Region: South
Division: New Mexico
City: ALB - Albuquerque
Site: Stormcloud 5

Stormwater Site Inspection Report

Inspection Date: 6/13/2019
Date/Time Entered: 6/13/2019 1:16:25 PM EST
Report #: 315211
Permit #: NMR10012Y
Permit Expiration Date:
NOI Start Date: 1/29/2018

### Concrete Washout Area

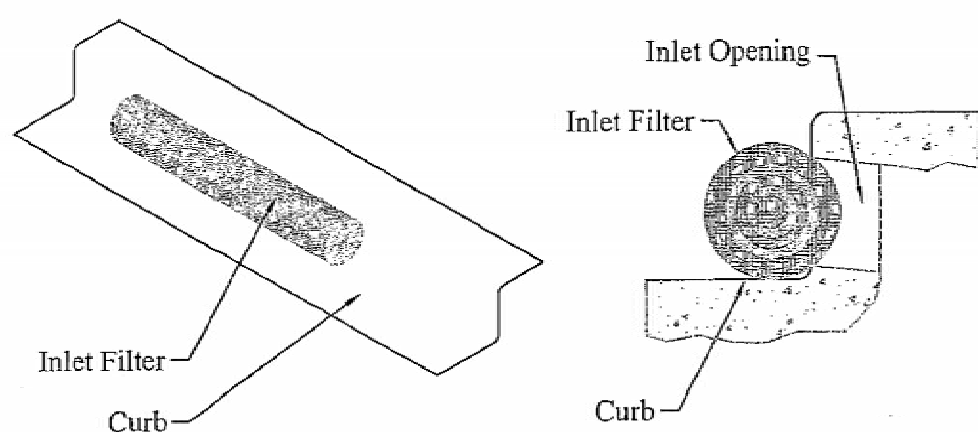
Ref#	Deficiency(Action Item)	Location	Verified By	Date	Responsive Action Taken
315211 - C1	Sweep street	Downburst			
315211 - D1	A cutback curb 4in depth is needed	8604 Downburst			
315211 - D2	remove dirt from topping over curb	8604 Downburst			
315211 - D3	A cutback curb 4in depth is needed	8500 camino del Venado			
315211 - D4	repair or replace silt fence	corner of watershed and forecast			
315211 - G1	Concrete washout pit about 70% full	Concrete washout area			
315211 - H1	Remove or contain construction debris from active lots	Roll cloud			
Additional Comments:
